Our Ref: EN020028

Date: 18 November 2024

Application by Morgan Offshore Wind Limited and Morecambe Offshore Windfarm Limited for an Order Granting Development Consent for the Morgan and Morecambe Offshore Wind Farms Transmission Assets project

Advice following issue of decision to accept the application for examination

Outline Public Rights of Way (PRoW) Management Plan (Doc J1.5), Outline Landscape Management Plan (Doc J2), Outline Highways Access Management Plan (Doc J8) and Onshore Biodiversity Benefit Statement (Doc J11)

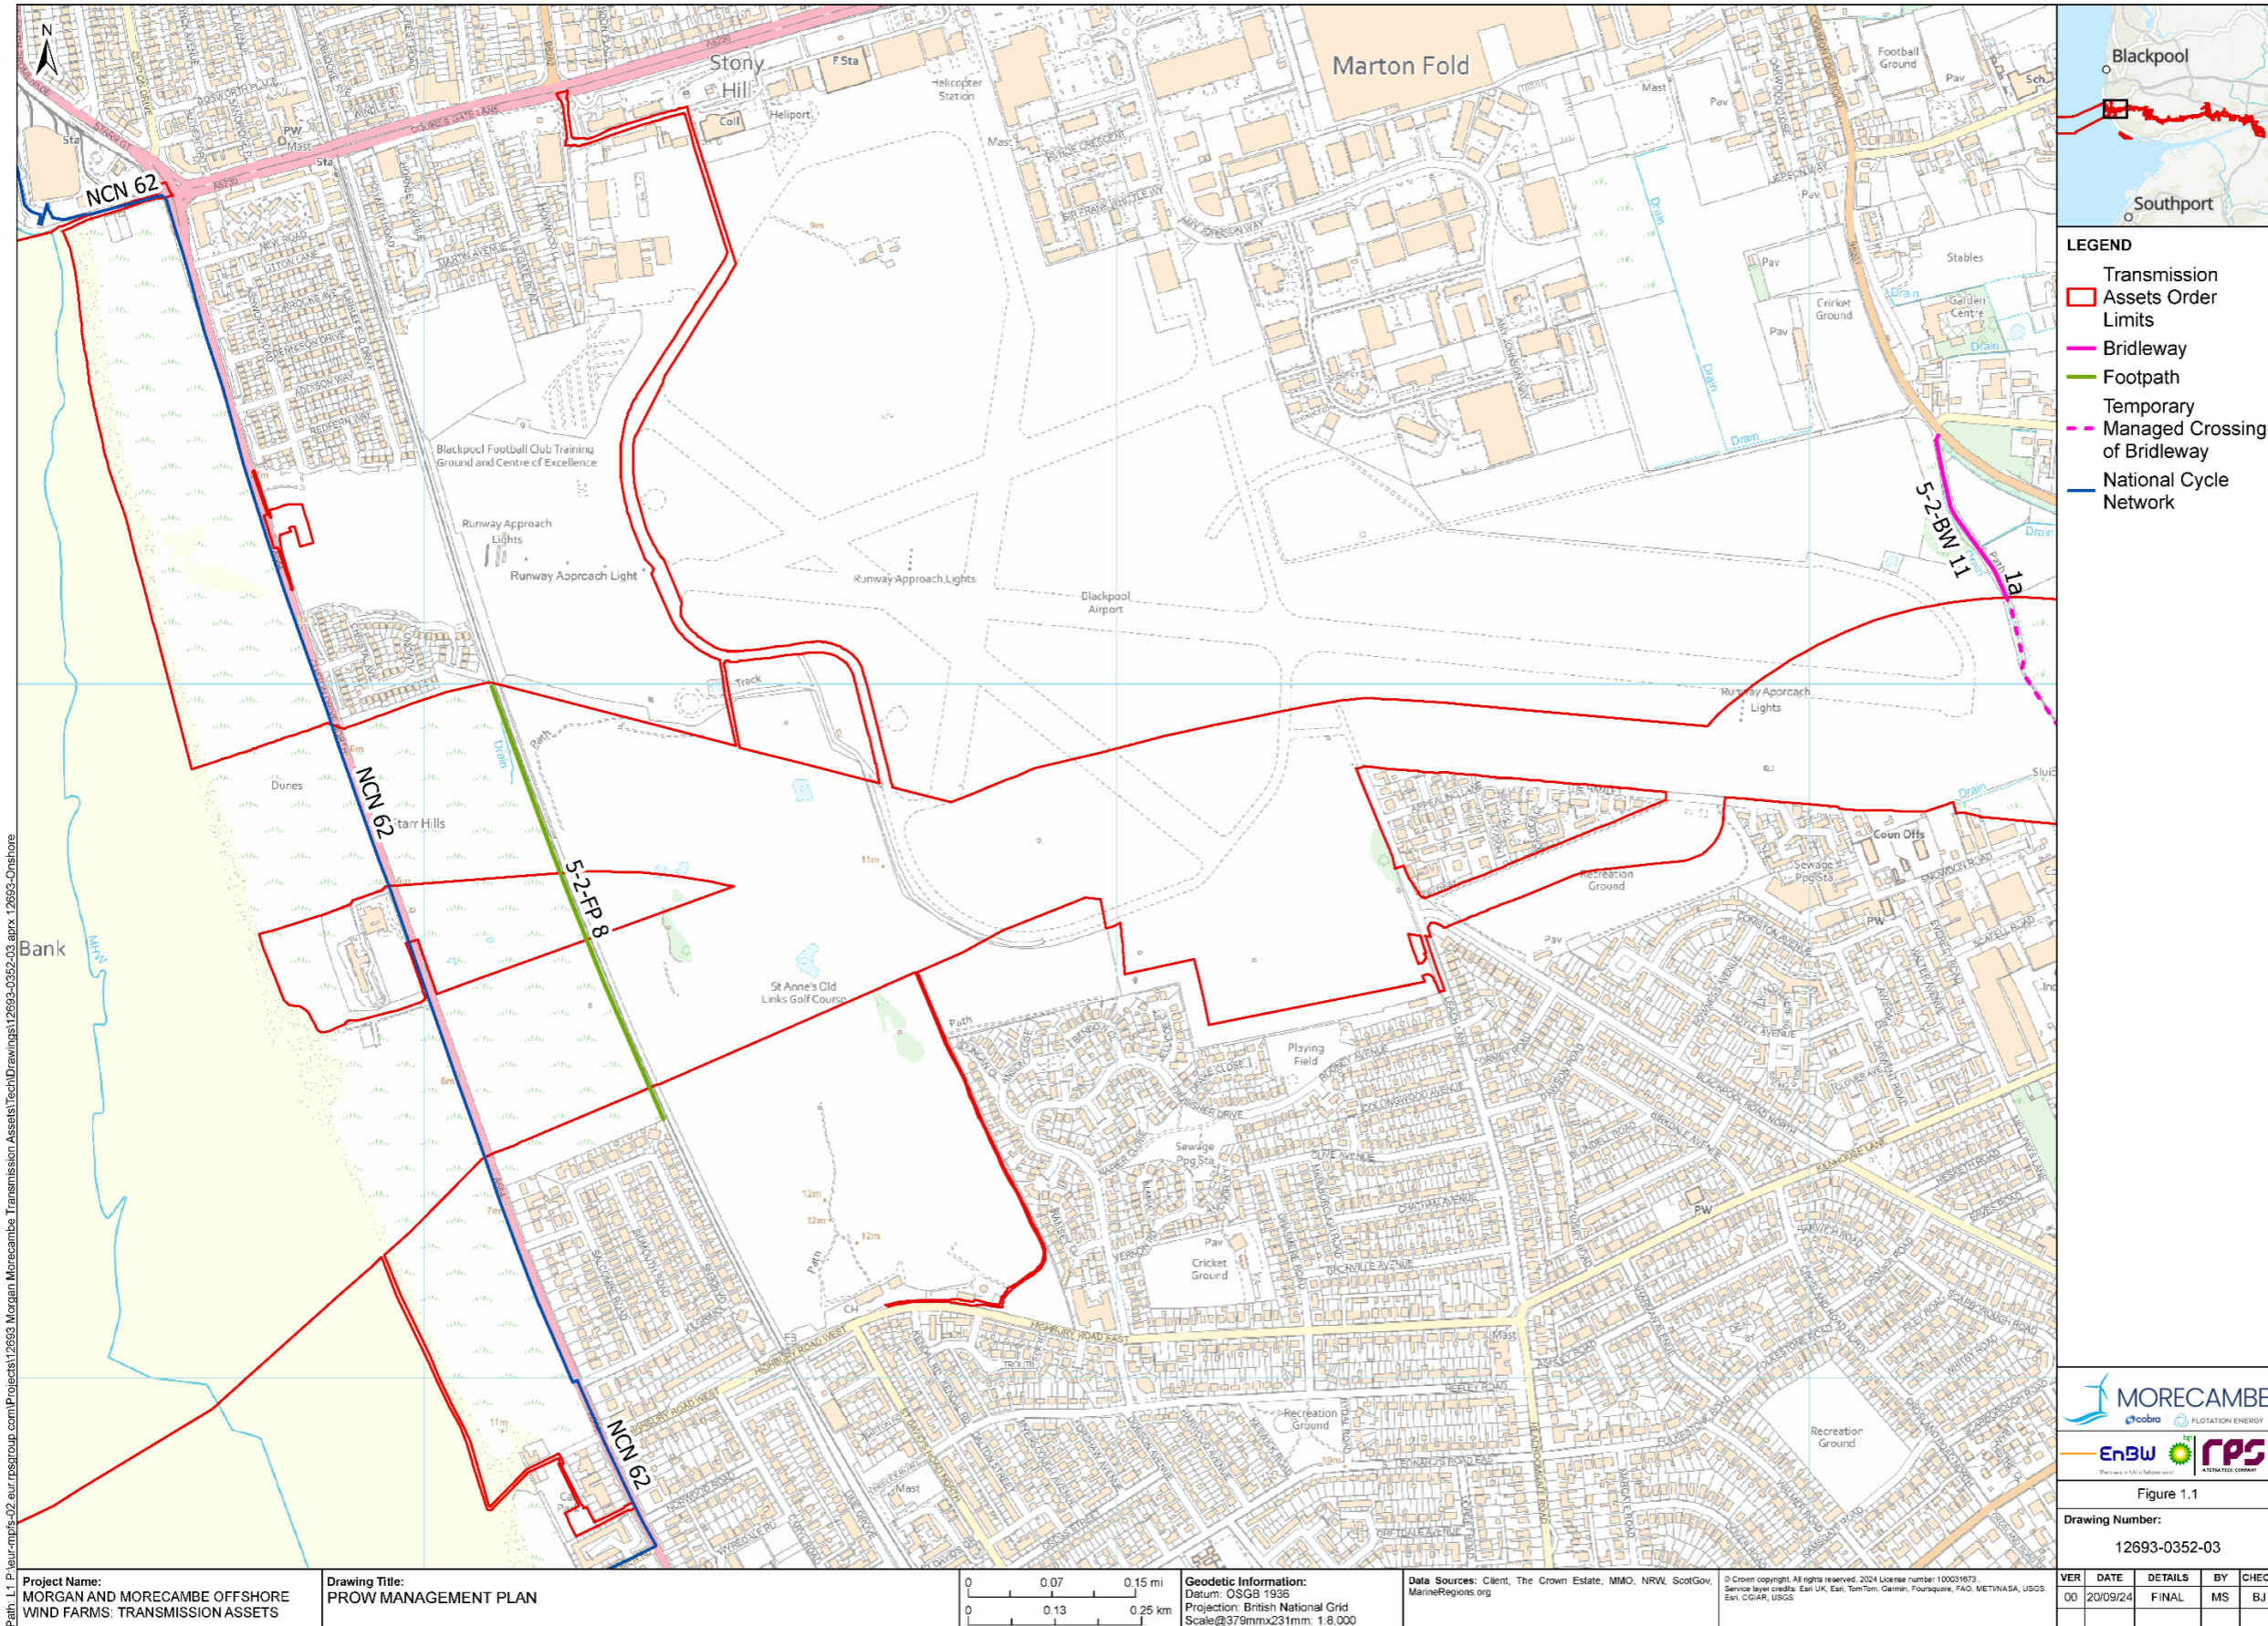
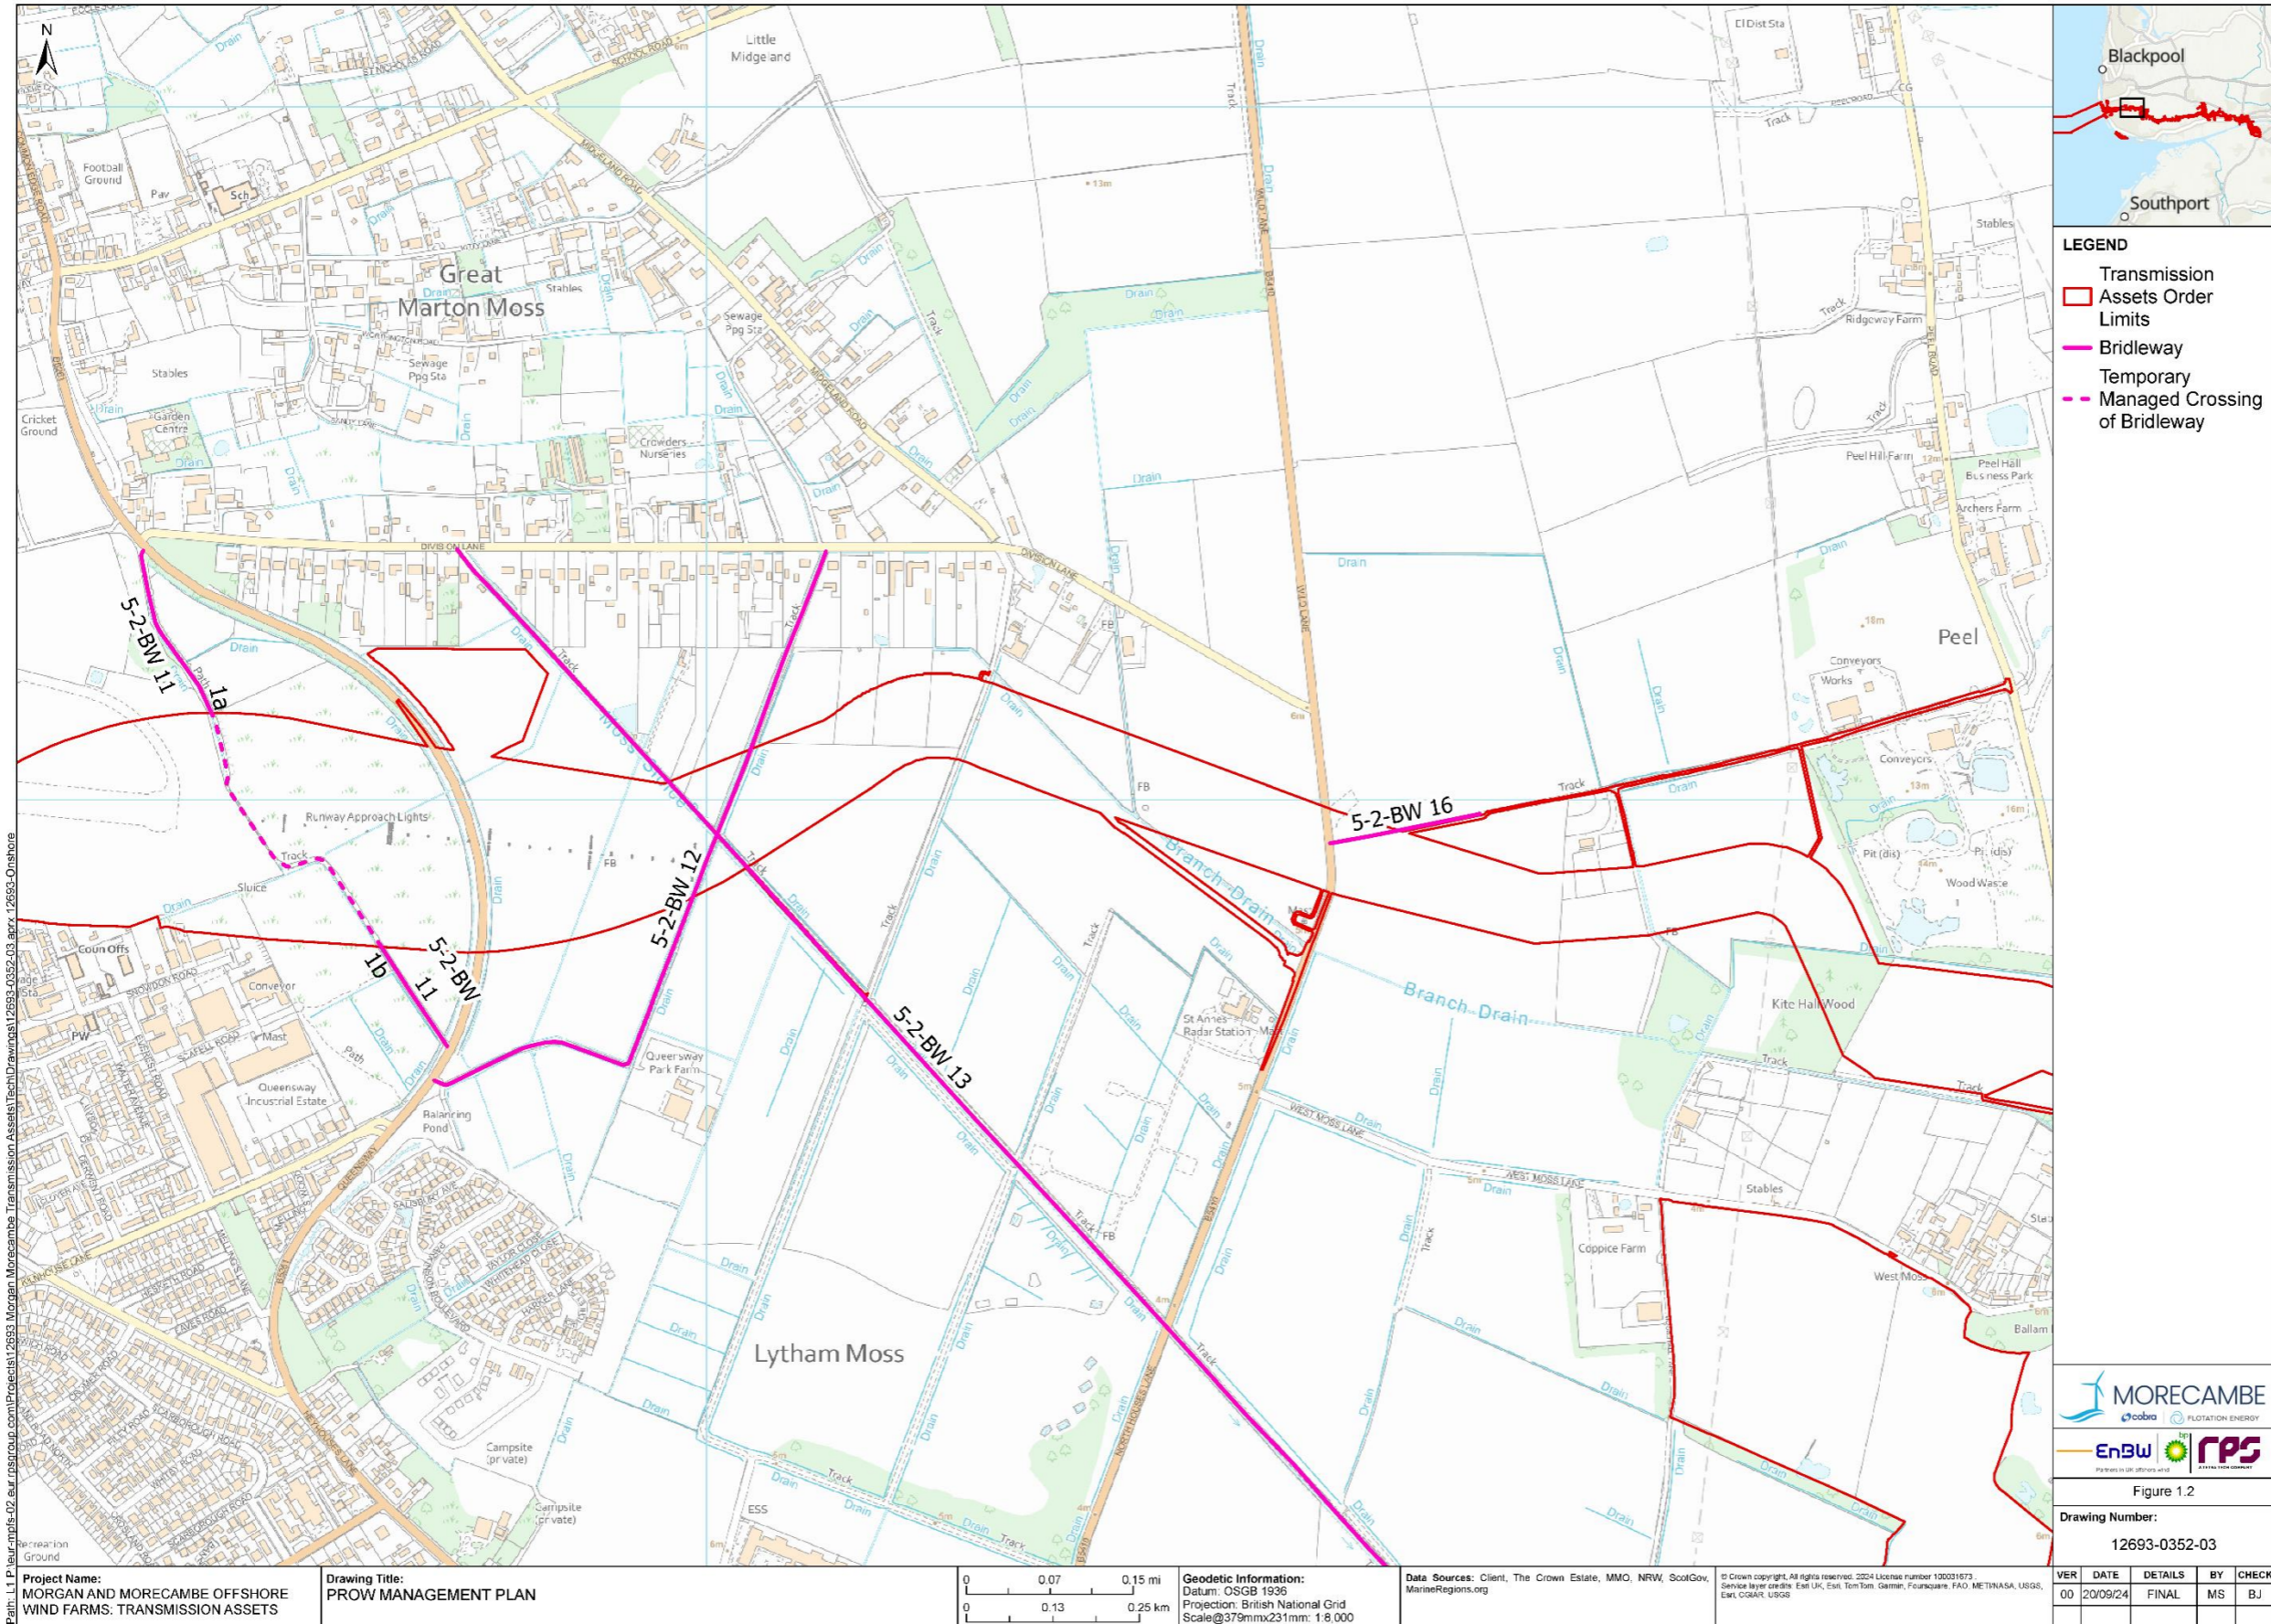
These plans should be reviewed for accuracy and readability, including how the keys/ledgers relate to the information portrayed on the plans.
